CITY OF ALBUQUERQUE

Re: Gallinger Studio/Apartments

Lots 8 & 9, Block 1, New Year Addition, 616 Washington St. NE

Grading and Drainage Plan

## GRADING & DRAINAGE PLAN

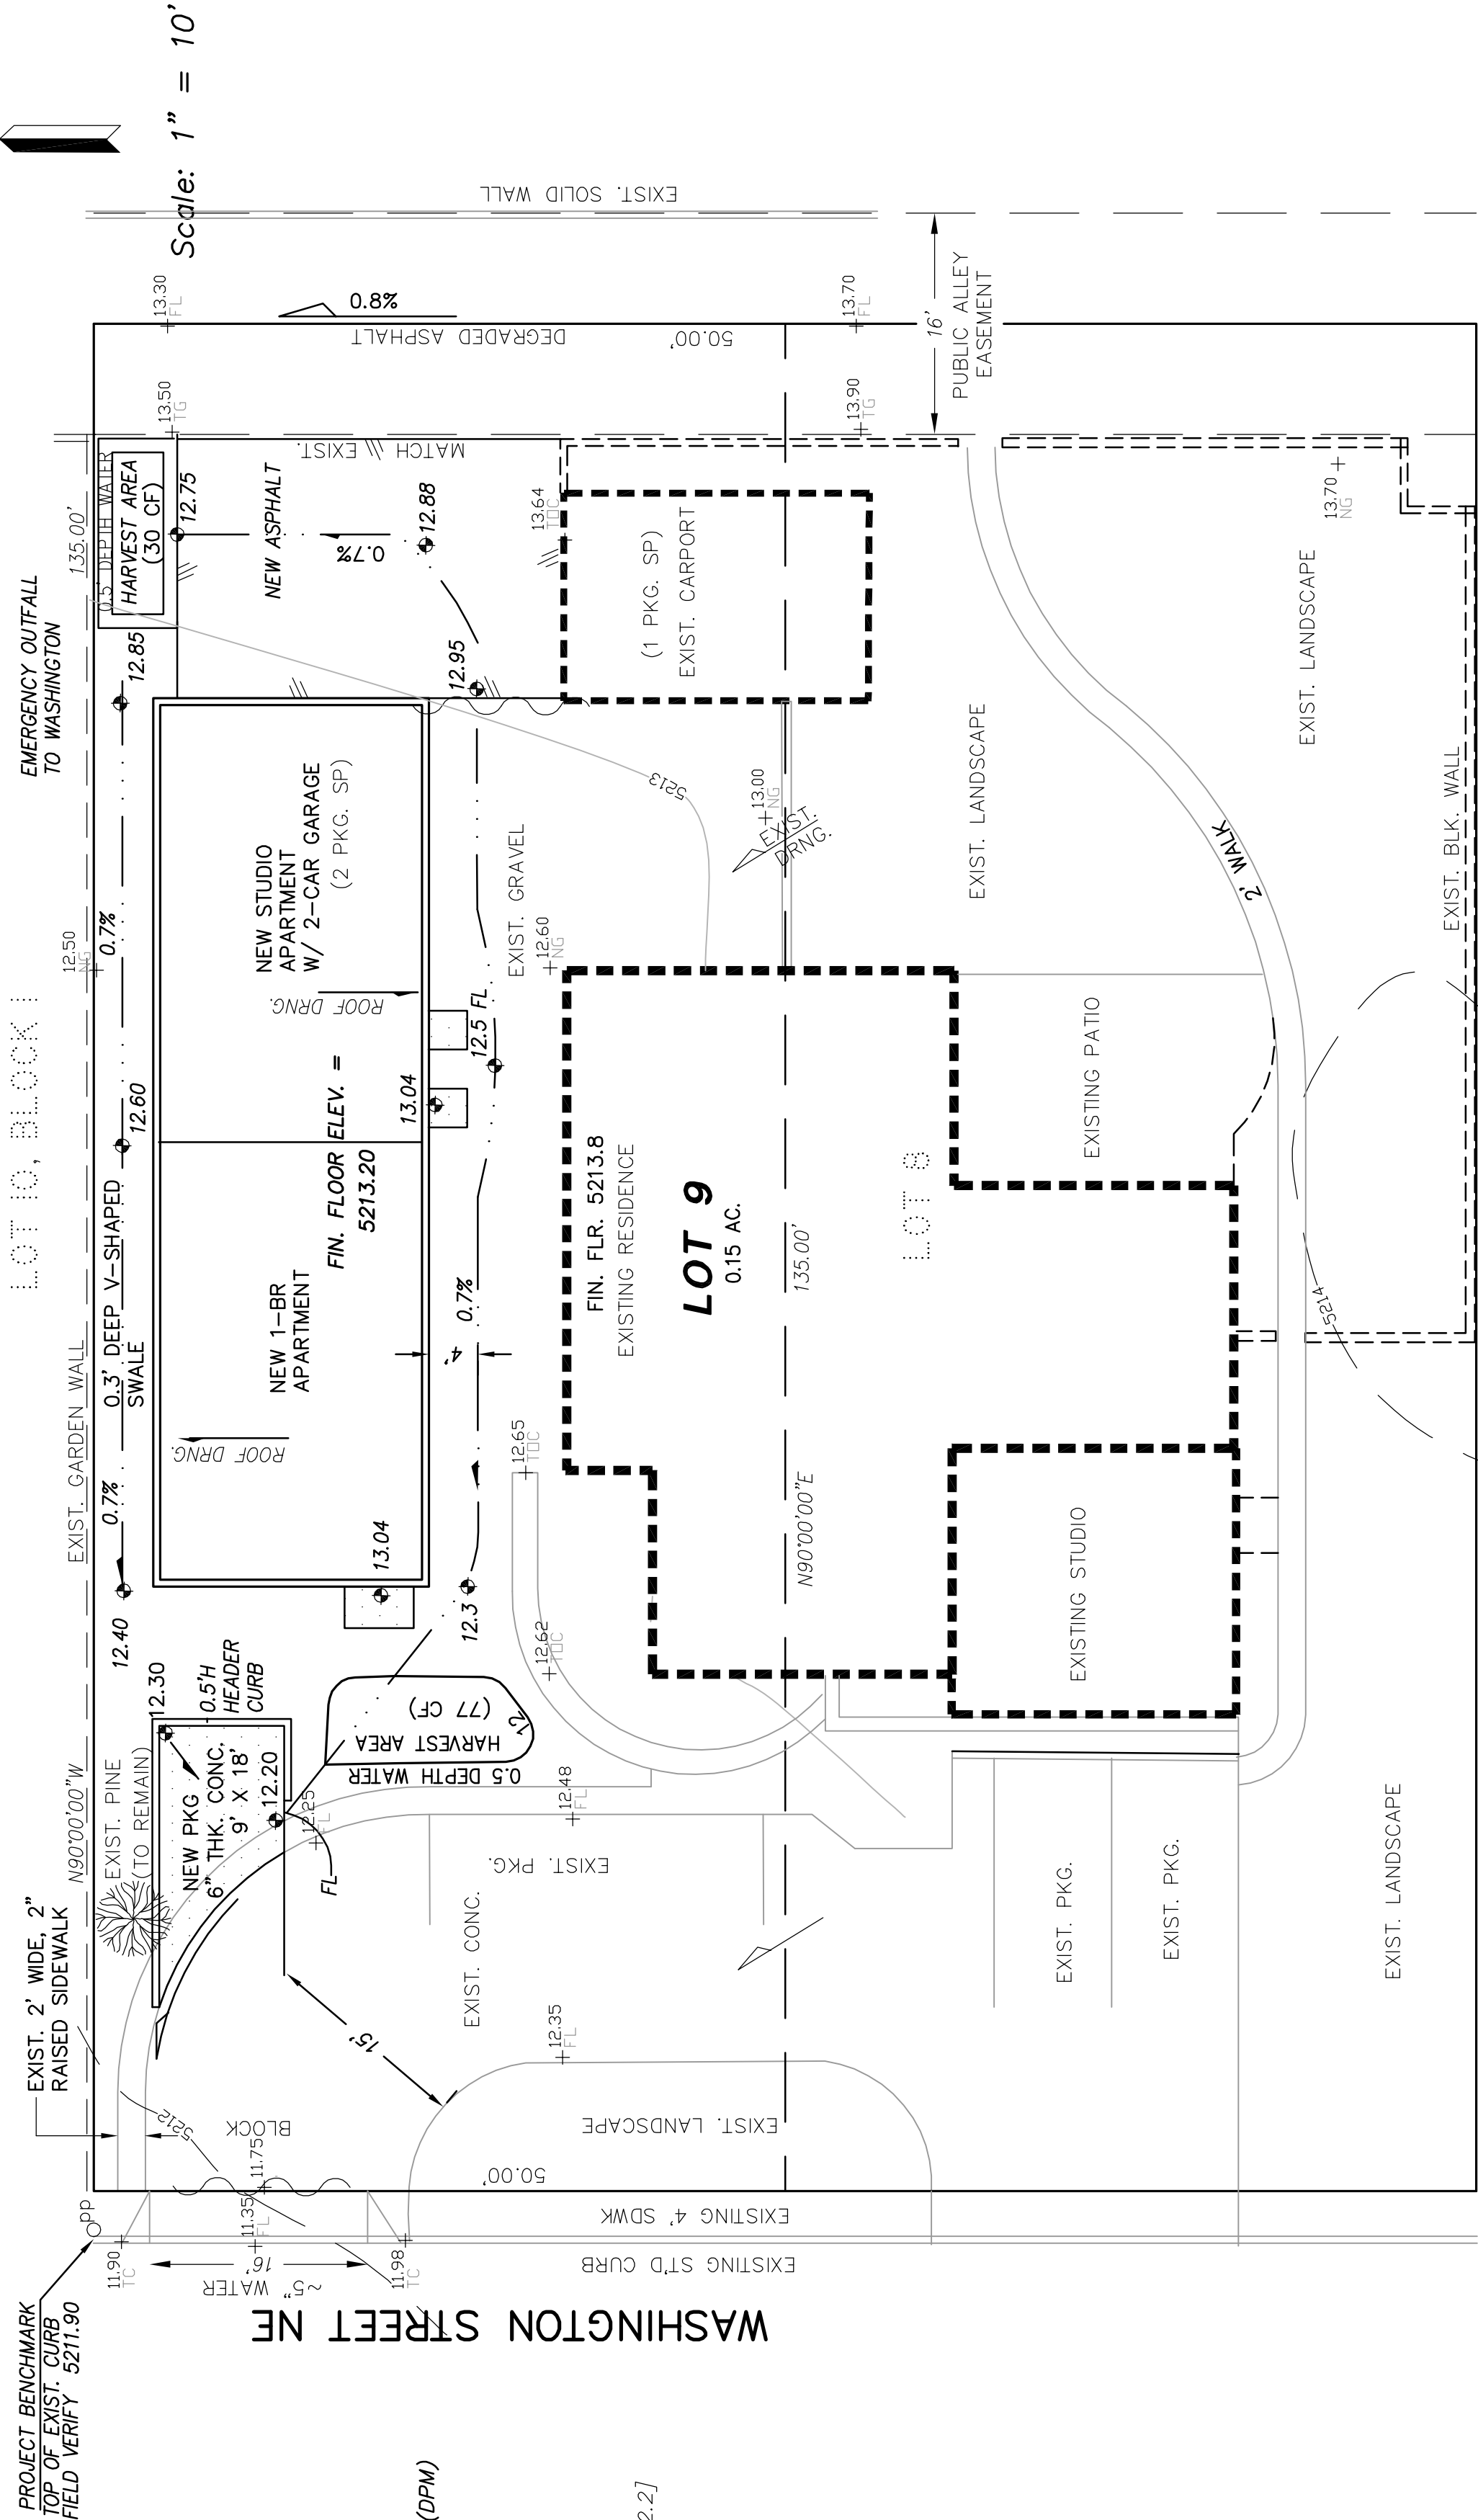
It appears that runoff will not be able to drain out to the alley.

I have attached an exhibit that shows positive flow from the back to the front.

- Change the title of the project to Galligner Studio... and Legal Description to Lots 8 & 9, Block 1, New
- How does Lot 8 drain? Does it enter Lot 9? Show roof flow directions for all the buildings.
- Show all the proposed and existing parking spaces. Is there any Handicap parking? Does it meet ADA?
- Show the doors and landings with spot elevations for the new and existing buildings.
- Show detail elevations along the alley to assure proper drainage.
- Provide additional elevations throughout the property around the buildings, along the property line and flow line in the street. Is there a water block at the entrances from Washington Street.
- At the NE corner of the project a wall is shown in the alley.
- Is there a swale proposed on the north side of the proposed buildings? Provide Detail.

I have never thought that shallow/very small water harvesting areas needed emergency outfalls. However, I think it is not a bad suggestion, have the grade as you noticed, and therefore changed out the northern most swale + added call-out "Emergency outfall to Washington". I can bring a hard copy as soon as my sched permits. thx again, Phil
